Ribchester Parish Council

PLANNING APPLICATIONS No: 3/12/0155 & 156

Application: New pub signs comprising 3(no) sets of individual letters (non illuminated), 1 (no) amenity board (non illuminated), 1(no) illuminated menu sign, 1(no) lantern and 5 (no) floodlights.

At: WHITE BULL, CHURCH STREET

42 w Low Energy Flood lights

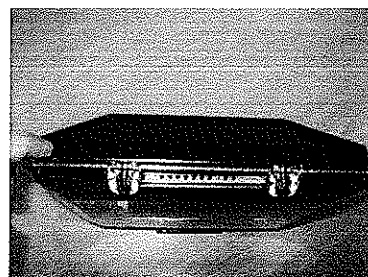
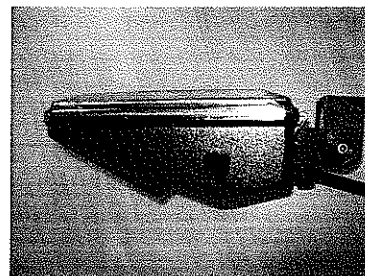
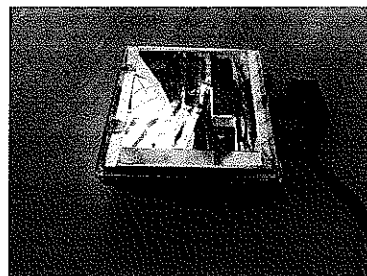
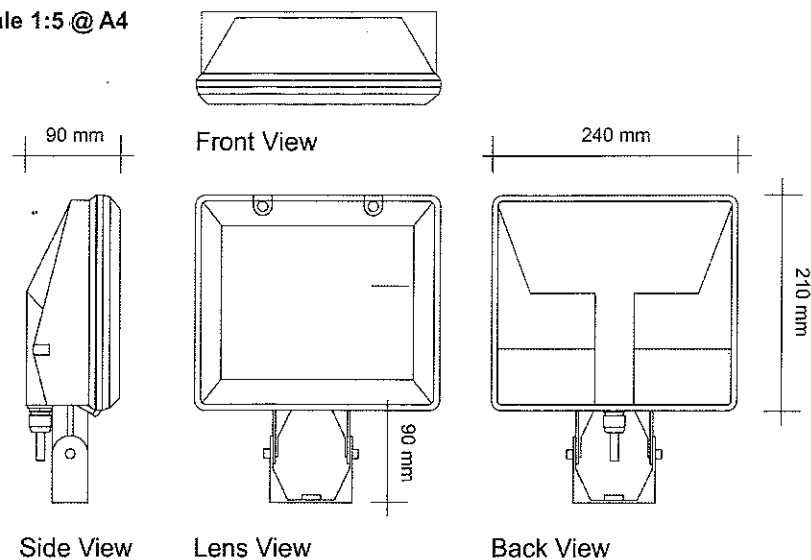
Careful consideration needs to be given to the lighting proposals. It must be borne in mind that the 'Hillock', on which the pub is situated, is surrounded by residences. The area must not be over illuminated.

SIGN B - scale 1:10

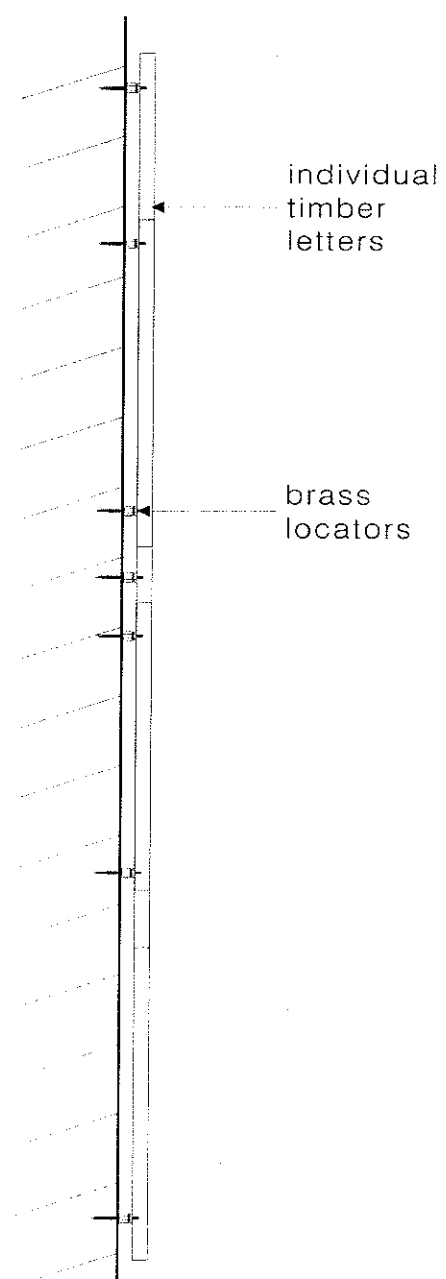
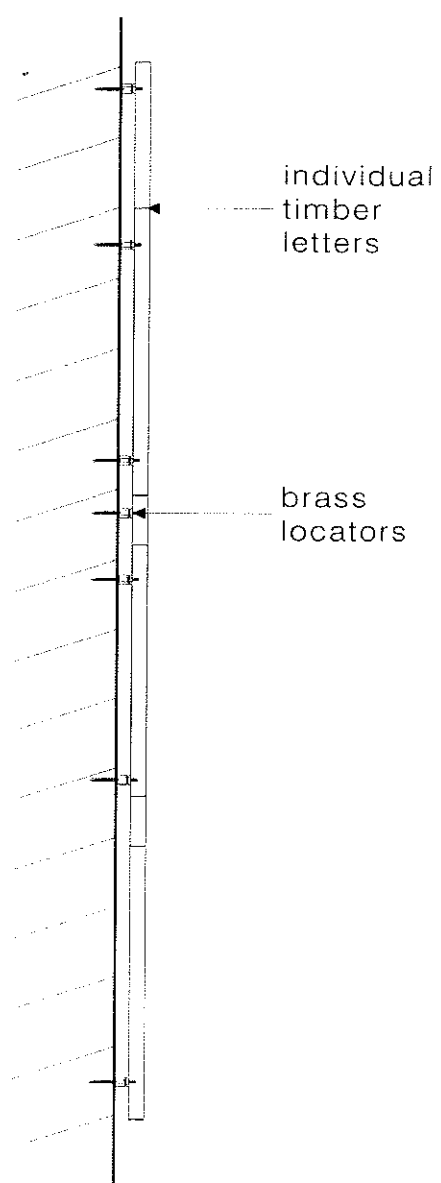
The rather extravagant calligraphy in respect of Signs 'B' and 'C' is out of place. It is suggested that the same font as sign 'A' be used.

SIGN D - scale 1:10

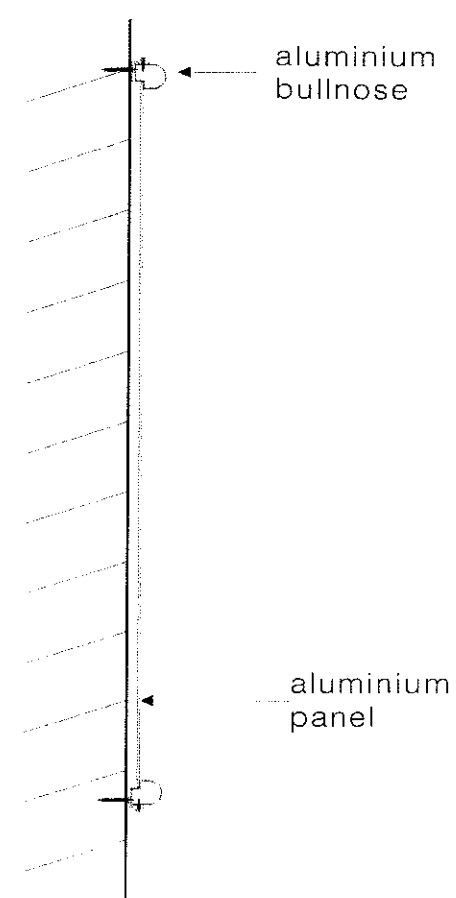
On page 1 of the heritage and planning statement there is a question about the meaning of the final sentence of the first paragraph. The suggestion is that the signage will be made from aluminium, although from other parts of the statement it is likely to refer to sign 'D' only.
